Demolition & erection of 1 No. dwelling.
7 Alleyne Way Elmer Middleton-On-Sea

Thank you for your internet representation made on 31st July 2019 which has been recorded as '**an objection**' with the comments as follows:

Proposed soakaway
4.8m(L) x 3.6m(W) x 0.84m(D)

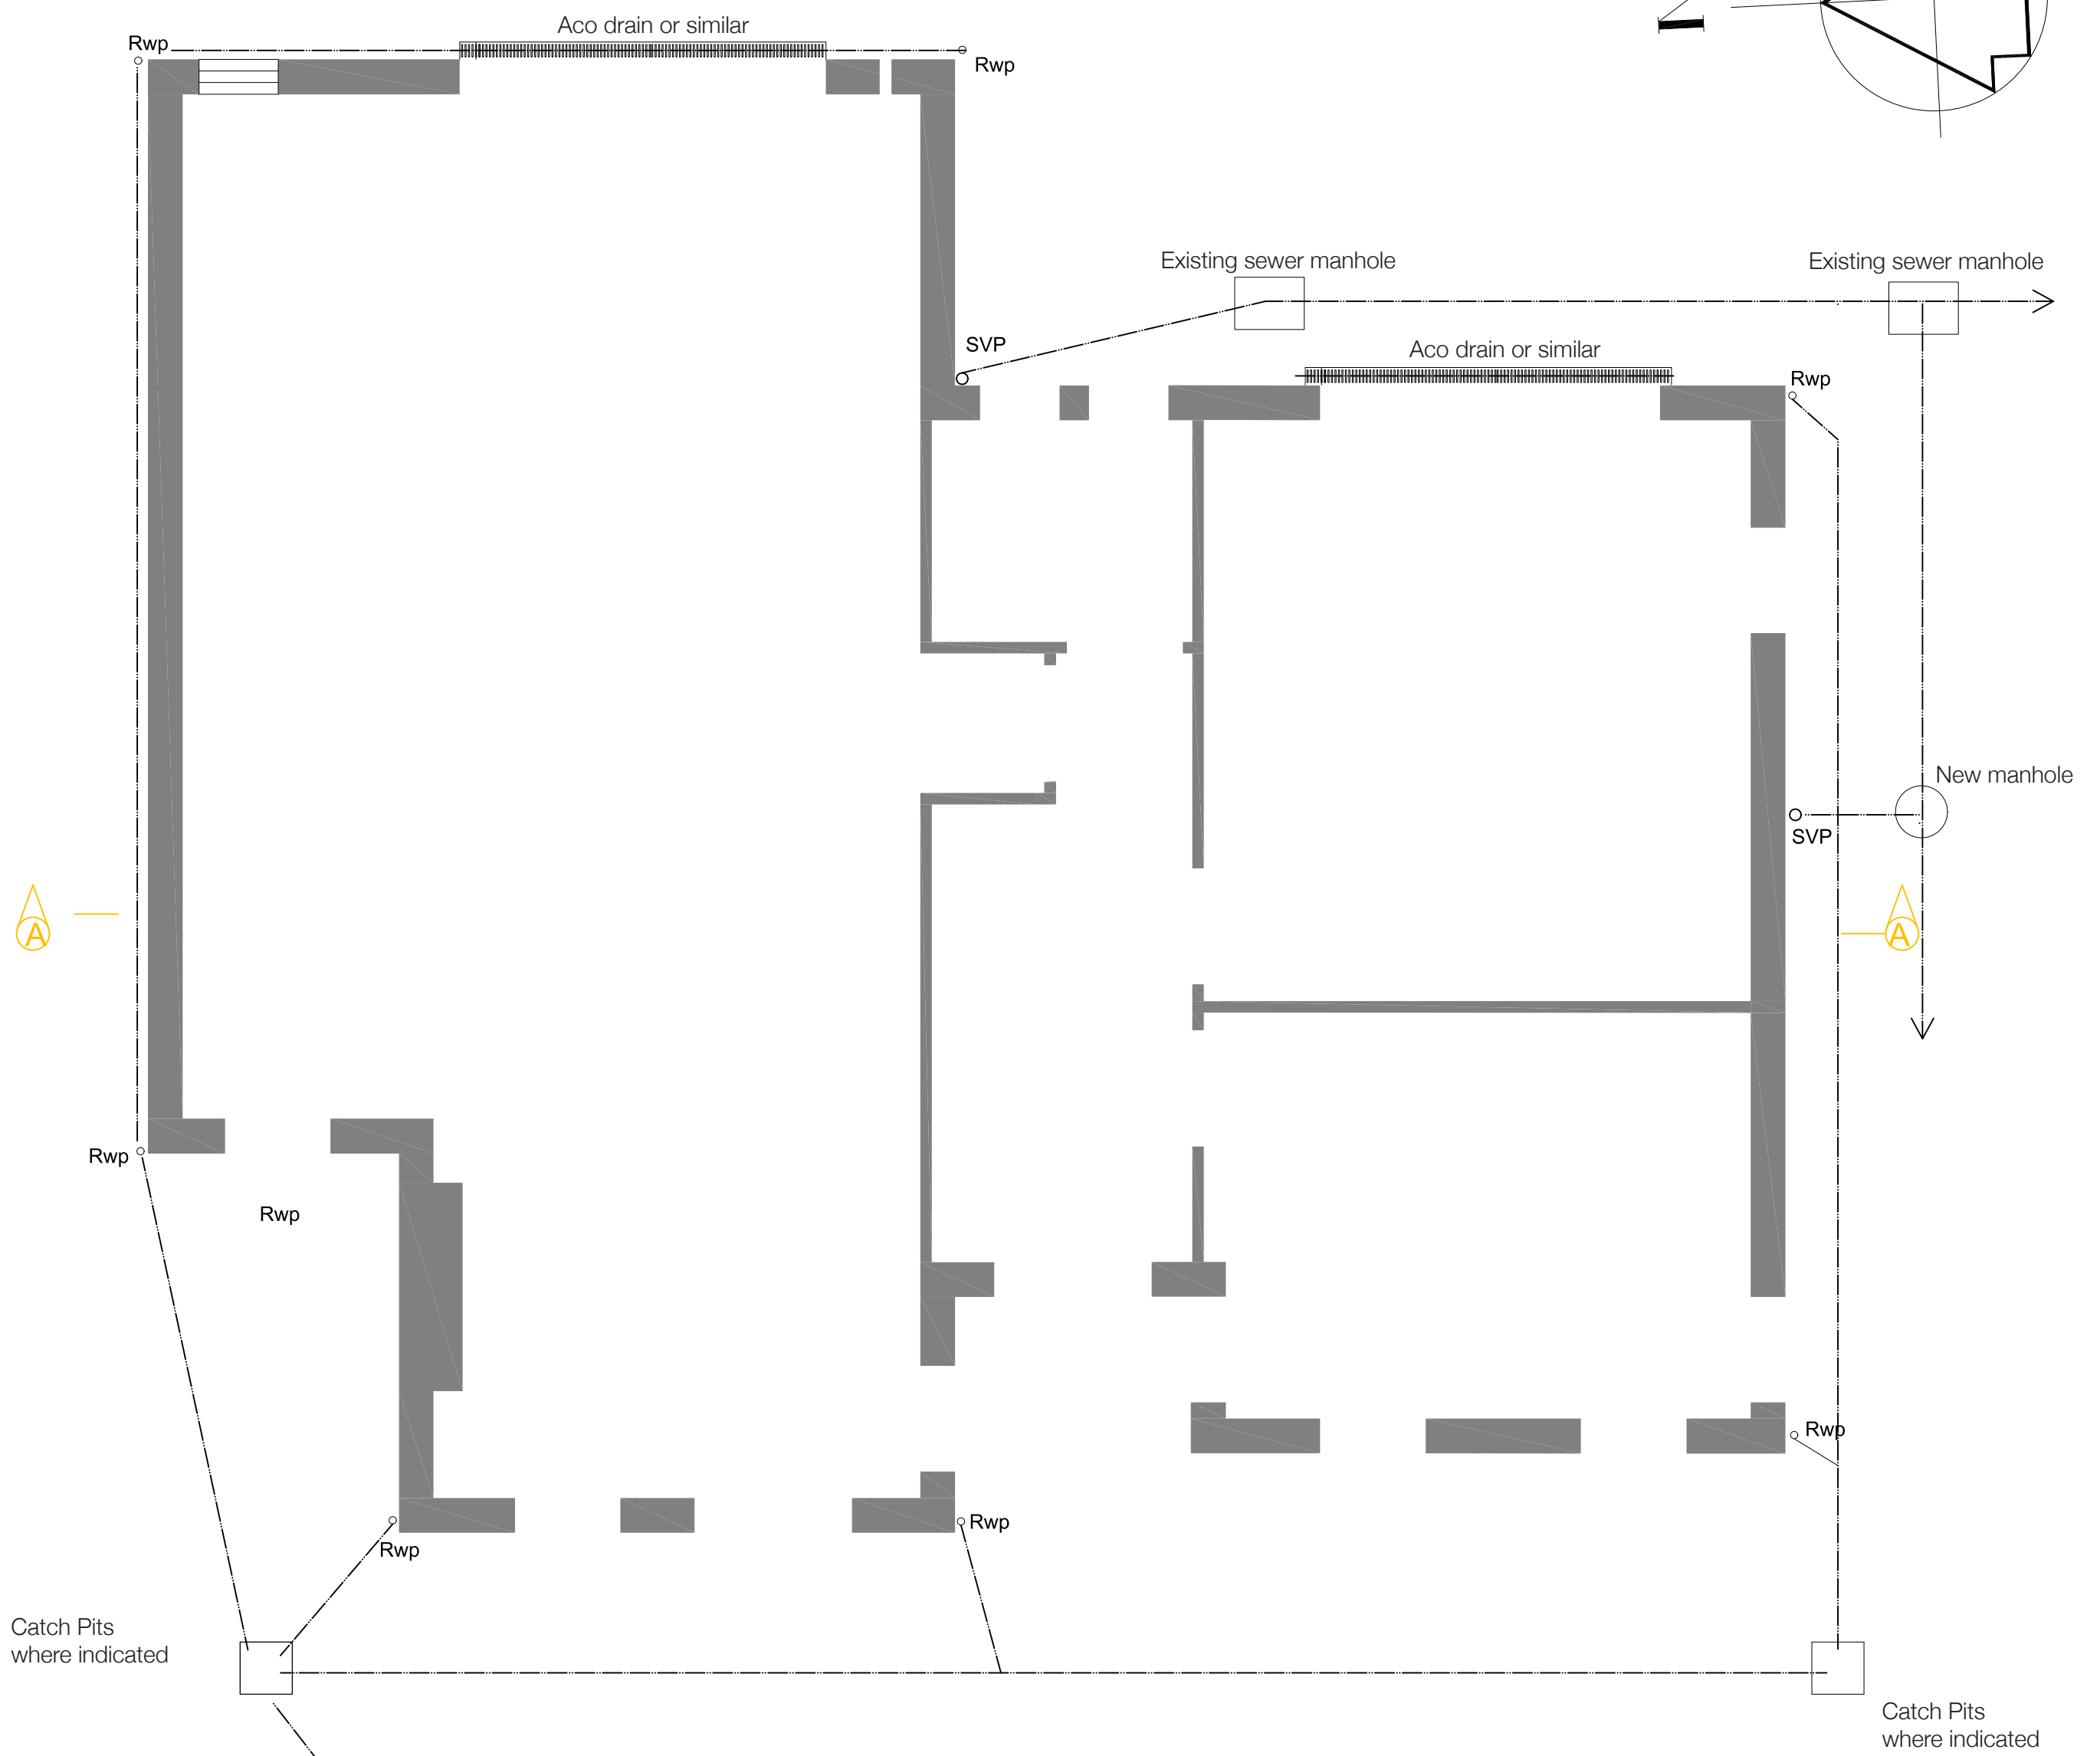
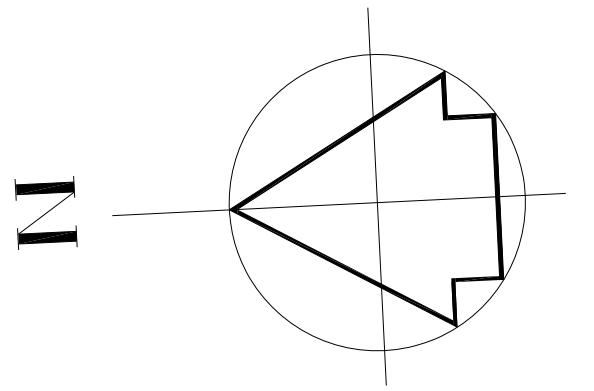
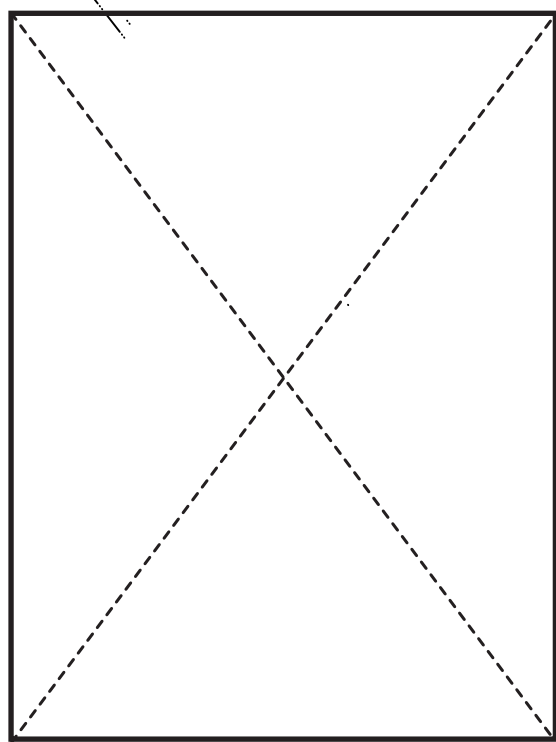
The drainage plan shown on the ADC Planning website linked to the 7 Alleyne Way application also appears incorrect as we believe it relates to 24 Alleyne Way. It shows the movement of a surface water soak away, which is sited on ESL land (road side), this is not acceptable as it is part of the ESL estate scheme to disperse surface water.
